27 August 2018

**Tweed Shire Council comments on the proposed North Byron
Parklands Cultural Event Site (SSD 8169) and modification of the
Concept Plan (MP09_0028 Mod 5)**

Figure 4.2 Site access gates A, B, C, D and E

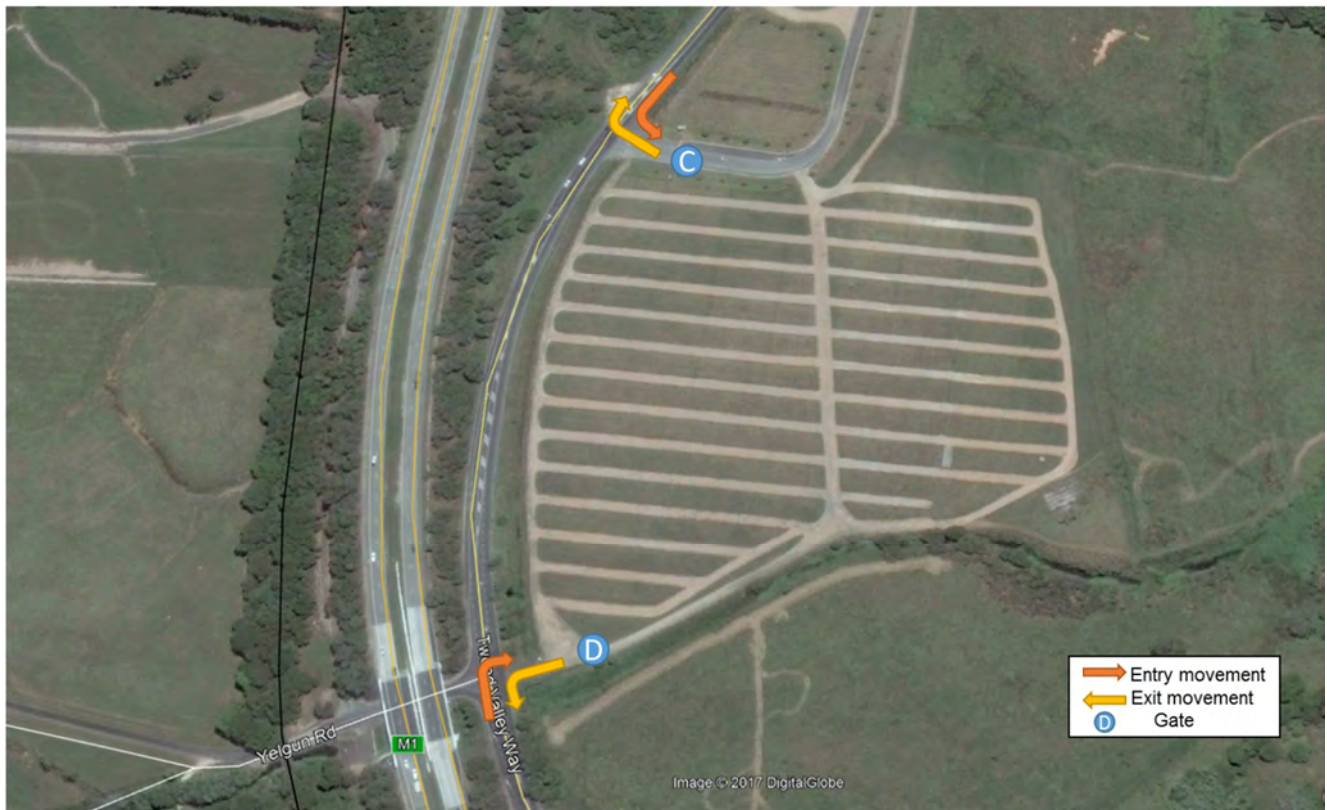
- a. Appendix C of the EIS indicates that the Gate E access is proposed to be constructed approximately 100m east of the existing access (see below). It would appear that the new access location is due to the existing emergency access being deficient in sight distance (as per the Austroads Guidelines). Limited detail has been provided for the realignment of the existing road. Further detail is requested with regard to long sections, proposed road widening (of Wooyung Road) or dimensions.

- g. There are no plans or indications as to where Gate E would be installed. This detail is considered to be important, as patrons entering the site would impact on the Wooyung Road if the Gate is located too close to the intersection. It is requested that a condition be applied requiring the placement of Gate E to be located at an appropriate distance from Wooyung Road, to ensure that vehicles entering the site do not queue onto Wooyung Road.

PLAN - WOYUNG RD

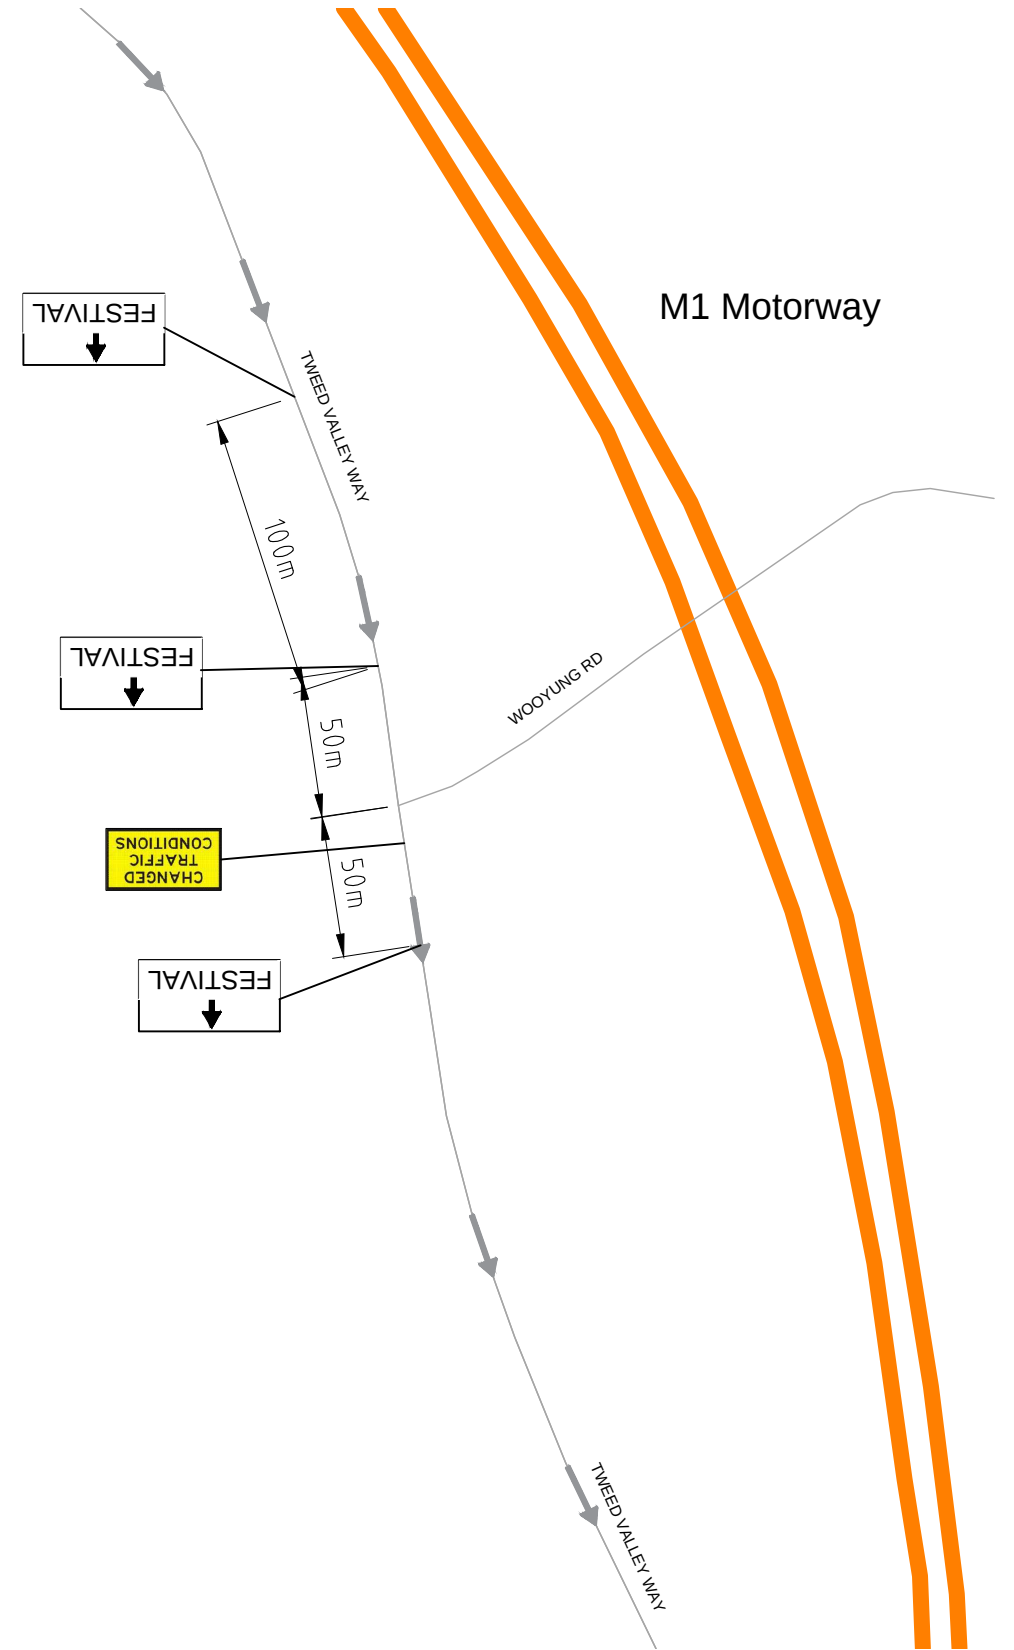
- d. Appendix P of the EIS incorporates a No Stopping Plan which includes Wooyung Road (highlighted below in pink). As noted previously, Tweed Shire Council does not support the installation of "No Stopping" signs on Wooyung Road, as this results in a resource issue in the enforcement of the signs. It is requested that the Traffic Control Plans be amended accordingly.
